Our Ref: 08092022_4795_RtS_Biodiversity

9 September 2022

RE: John Hunter Hospital Health and Innovation Precinct Project (SSD-9351535 MOD2) – Vegetation Clearing

FIGURE 2.1
Landscape Features

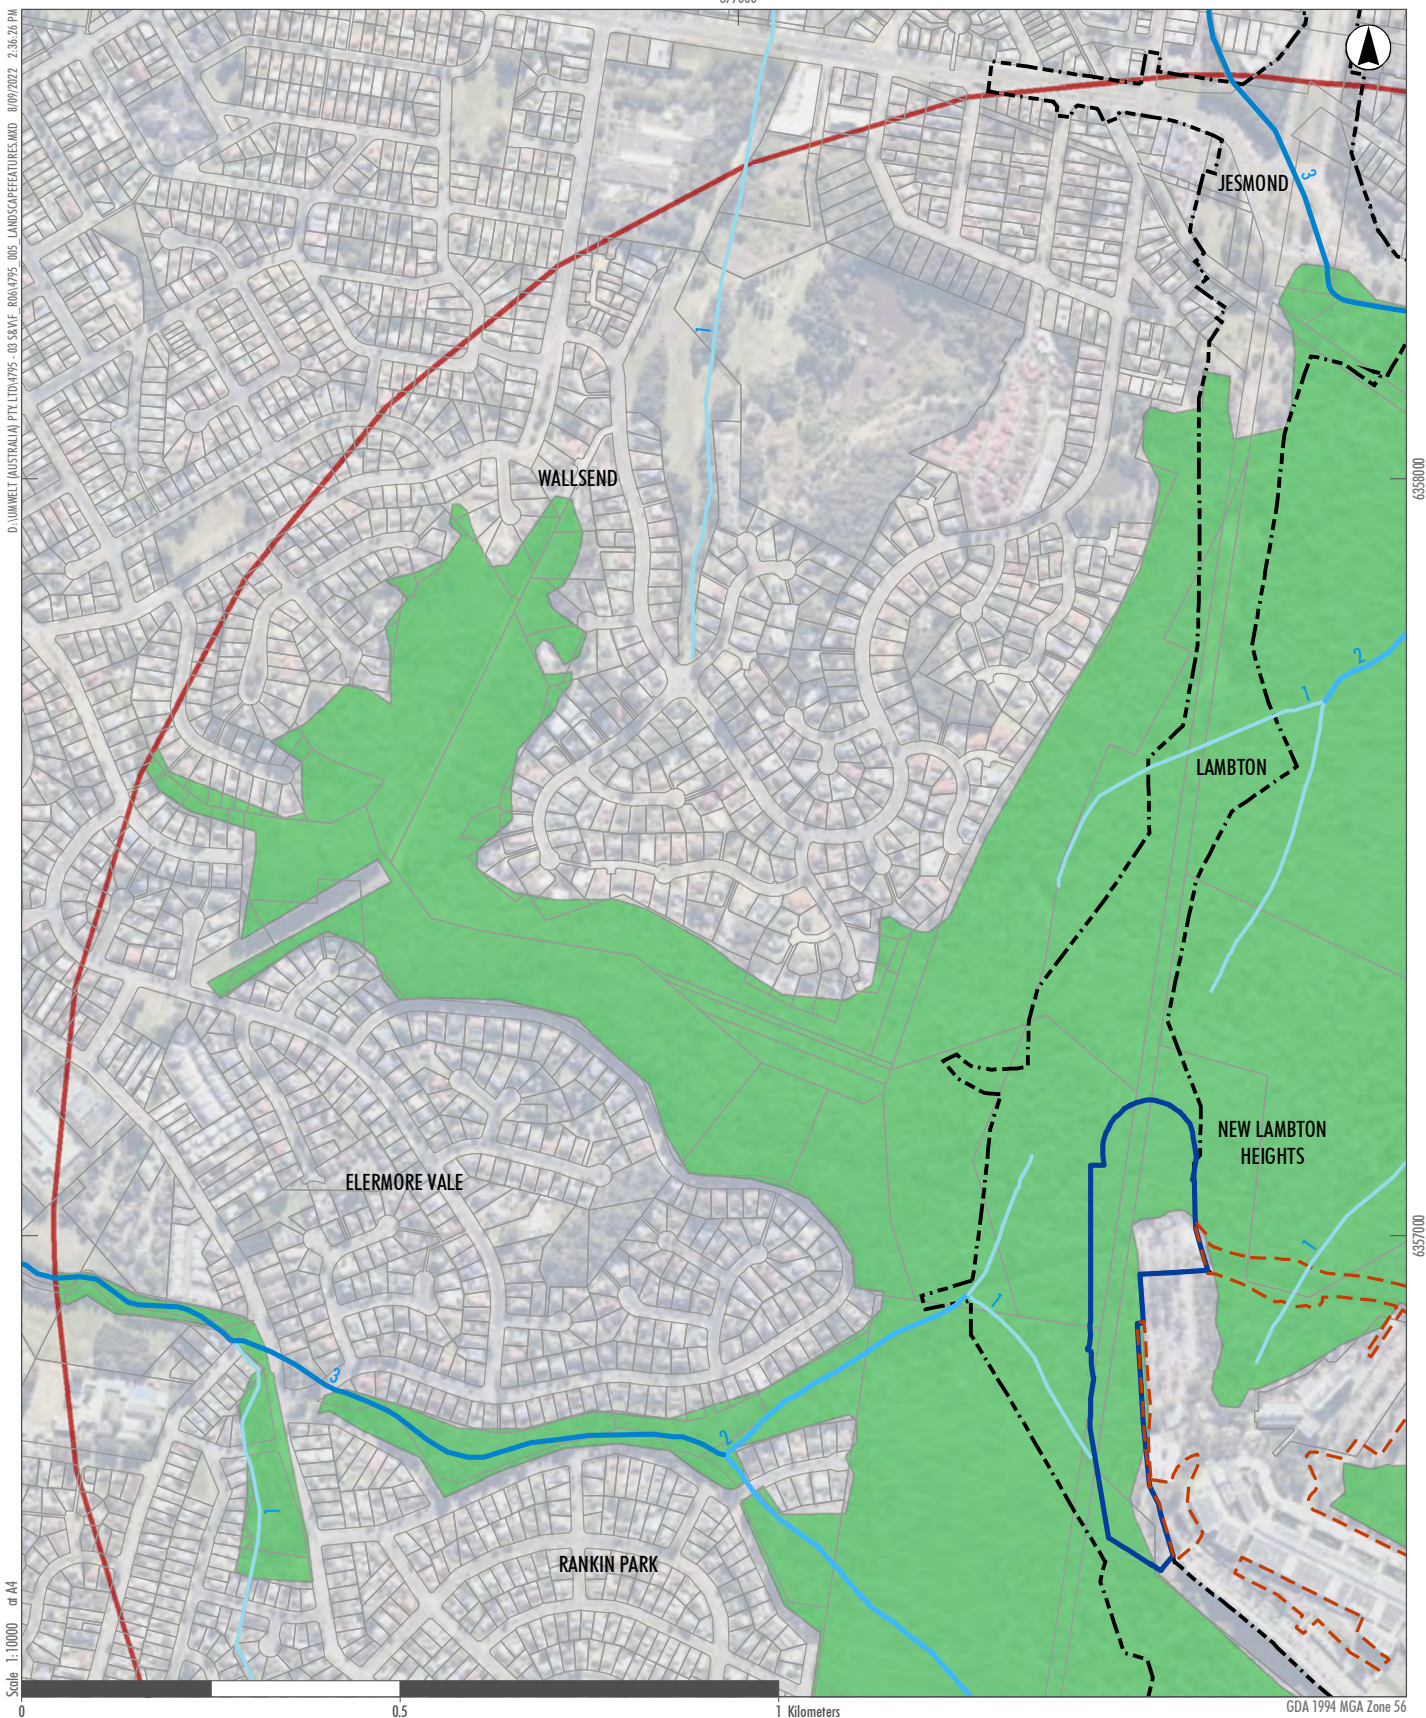
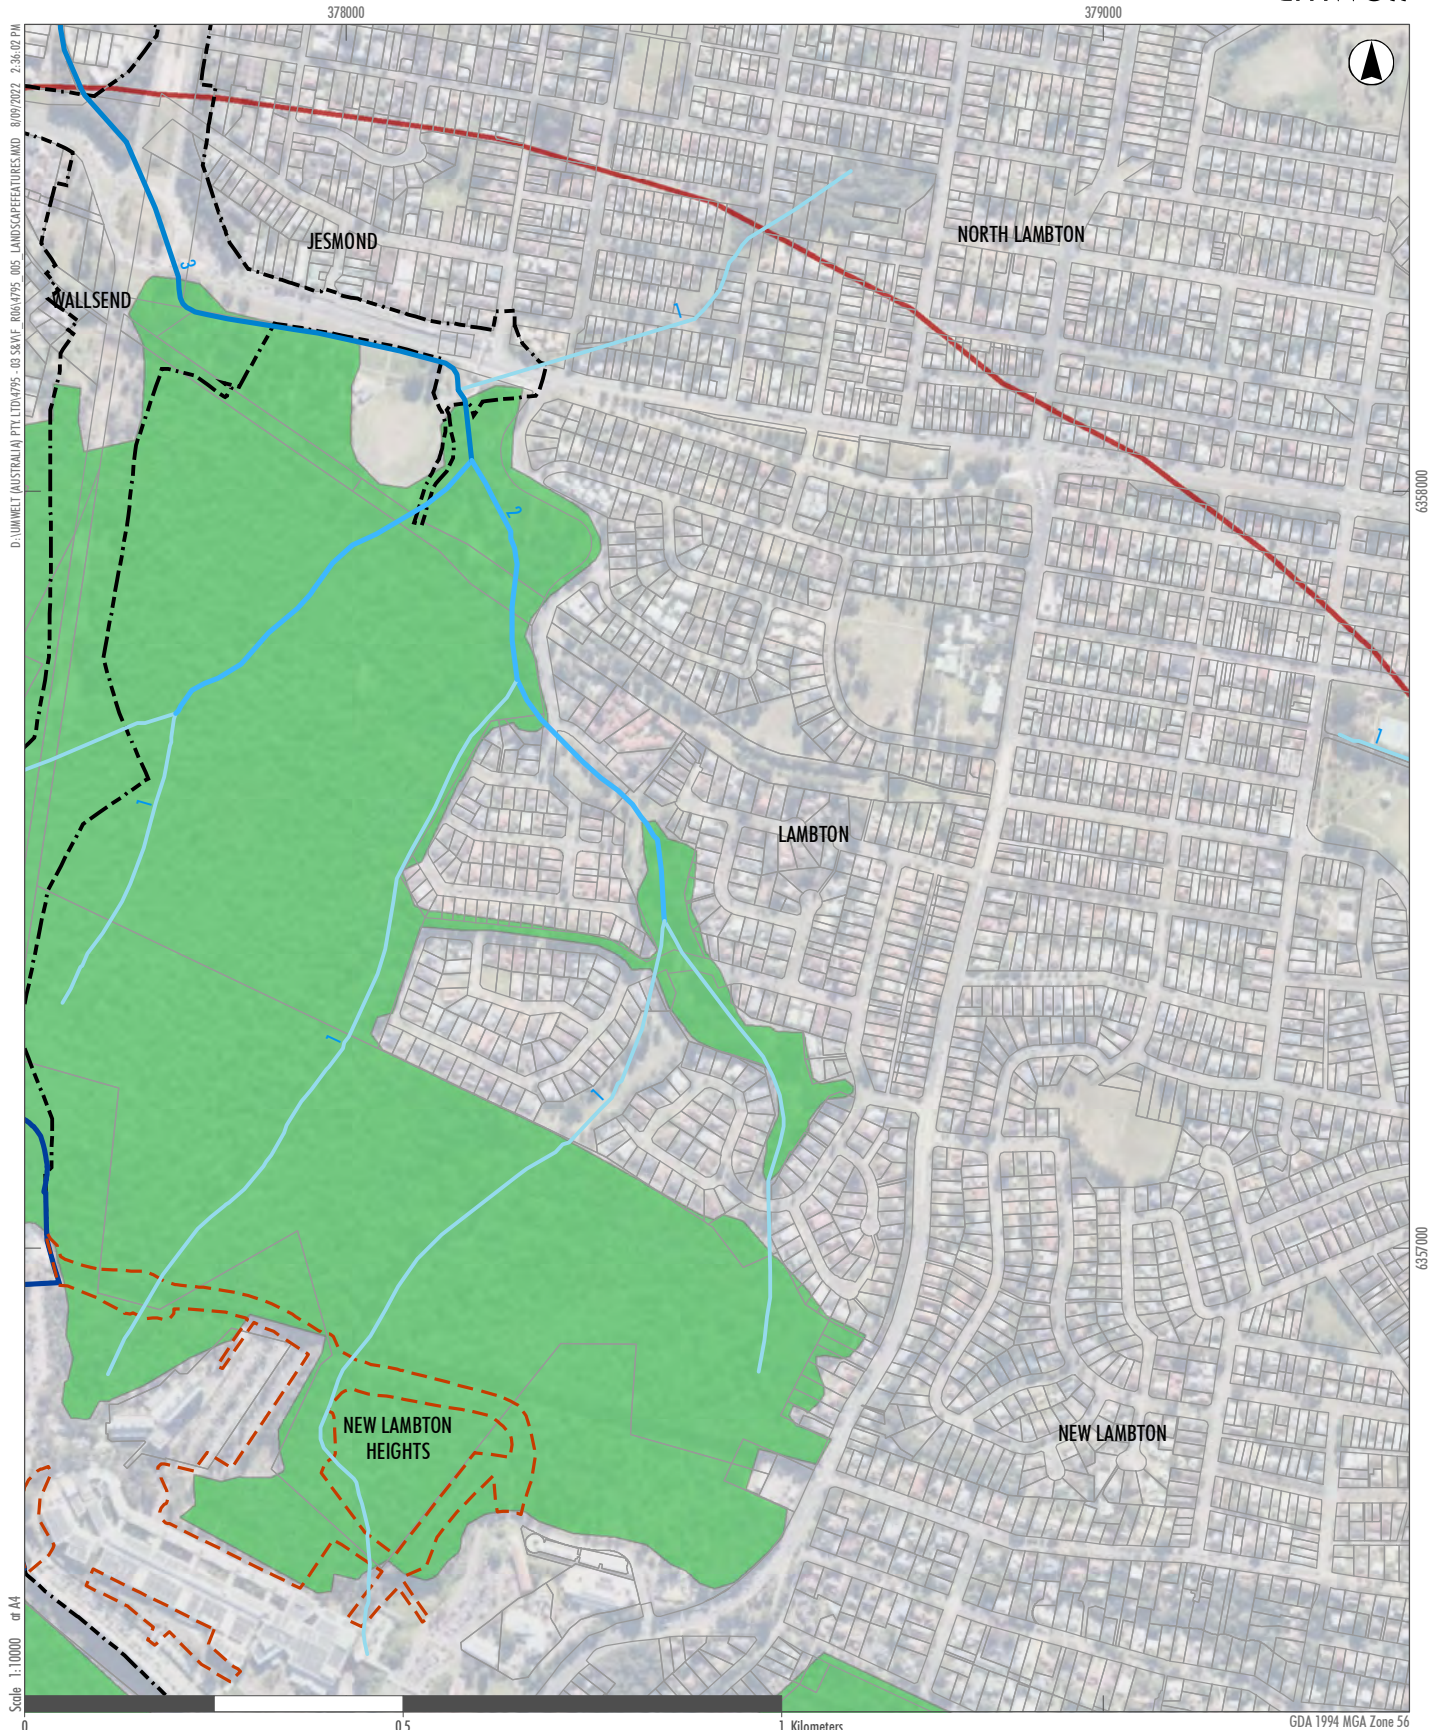
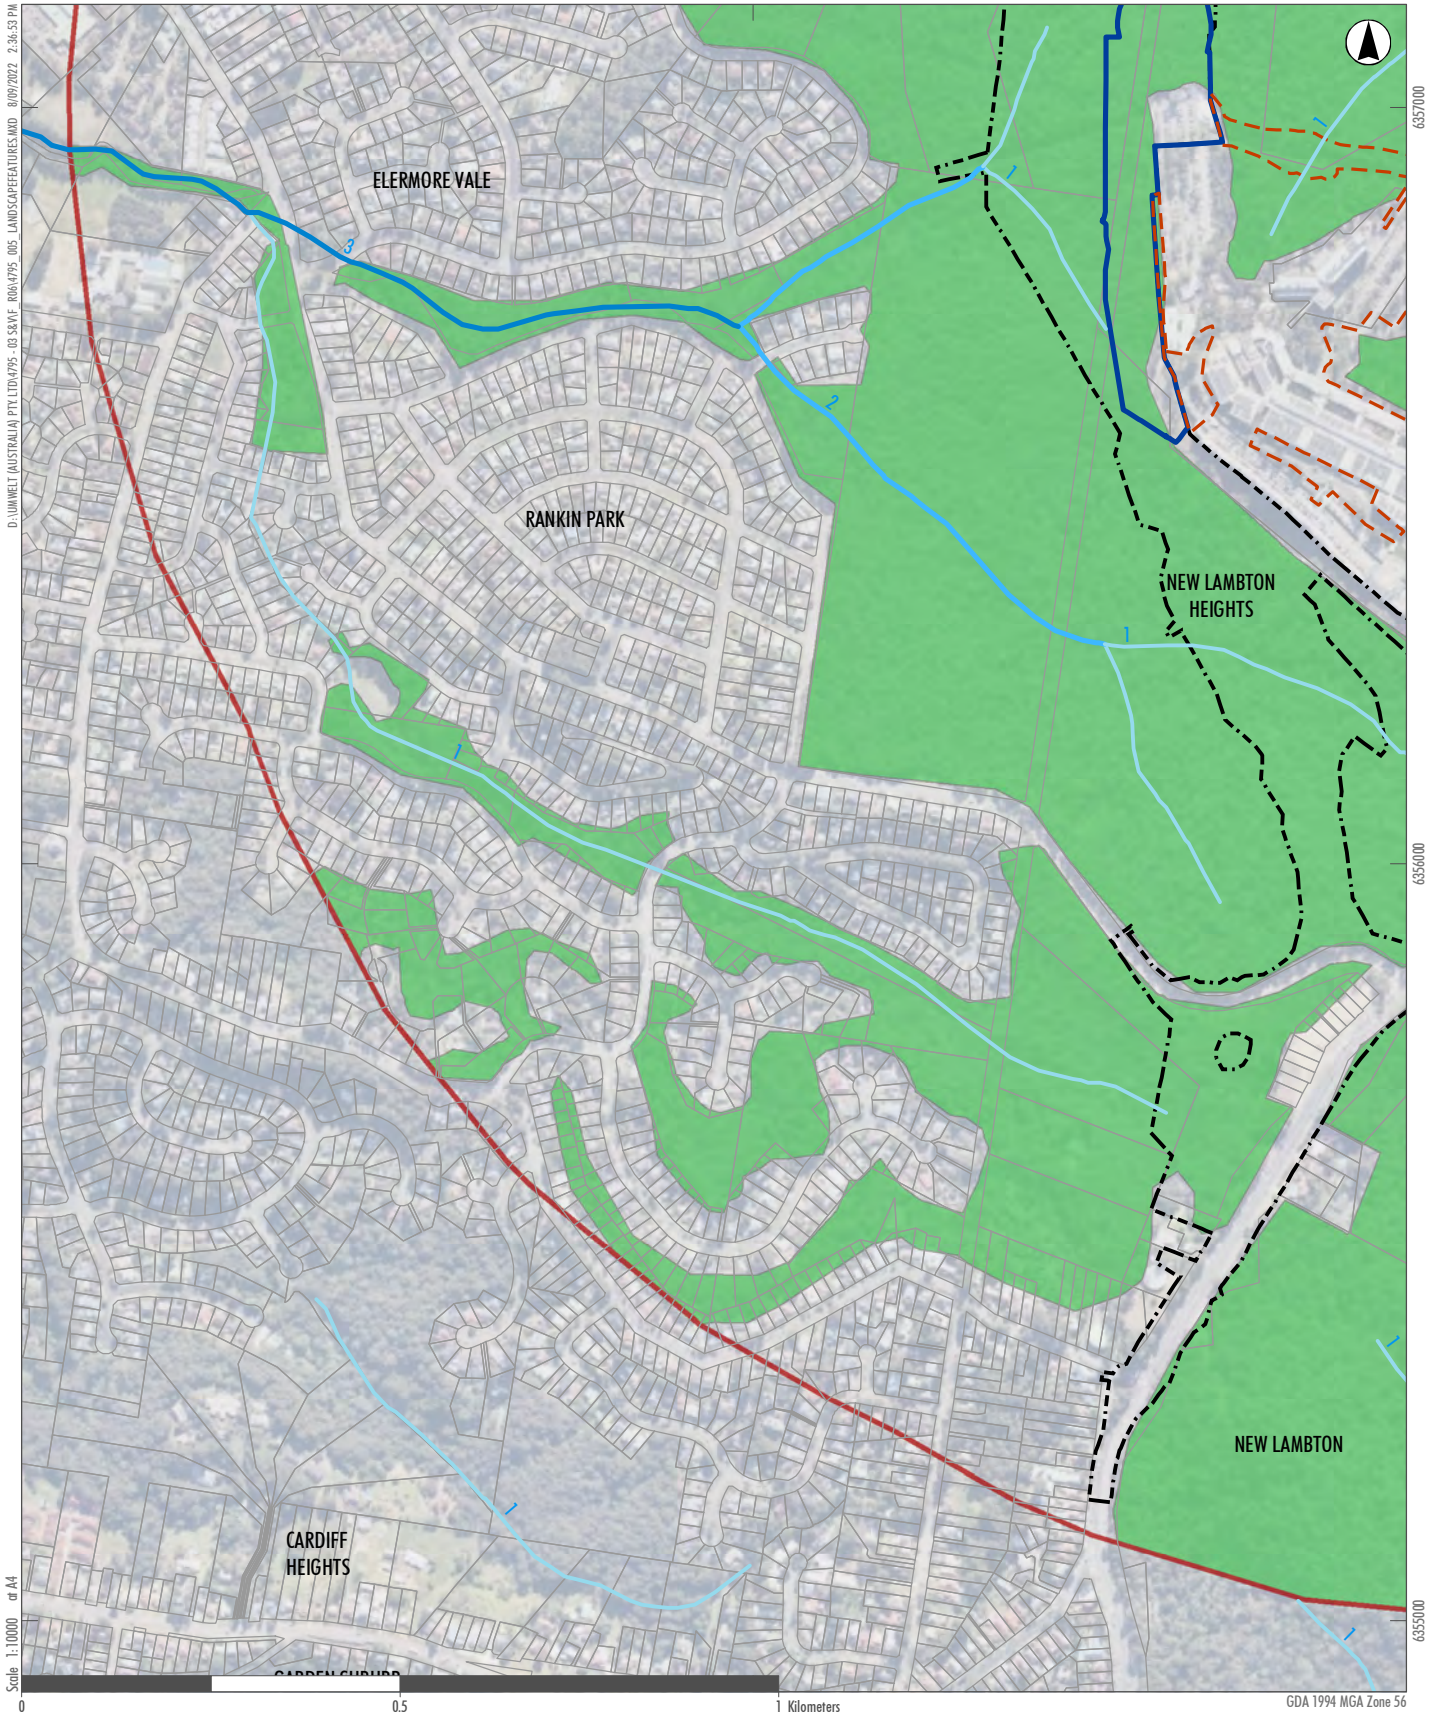
5. BCD recommends that existing maps are revised, or new maps are prepared that show all features required by the BAM.

- 10. BCD recommends a map showing the extent of native vegetation is provided that is at no more than 1:10,000 scale in order to meet requirements of the BAM 2020.**

The entirety of the area shown on all maps is covered by the same IBRA region, IBRA Sub-region and Mitchell Landscape, being the Sydney Basin IBRA region, the Wyong IBRA sub-region, and the Gosford – Cooranbong Coastal Slopes Mitchell Landscapes. It is therefore not possible to show boundaries for these at a relevant scale. Rather than showing the two IBRA layers and Mitchell Landscapes layer on each map and cluttering the figures, each map identifies the IBRA and Mitchell Landscape detail below the legend.

Cadastral has been added to all maps.

Relevant figure has been altered in revised report.
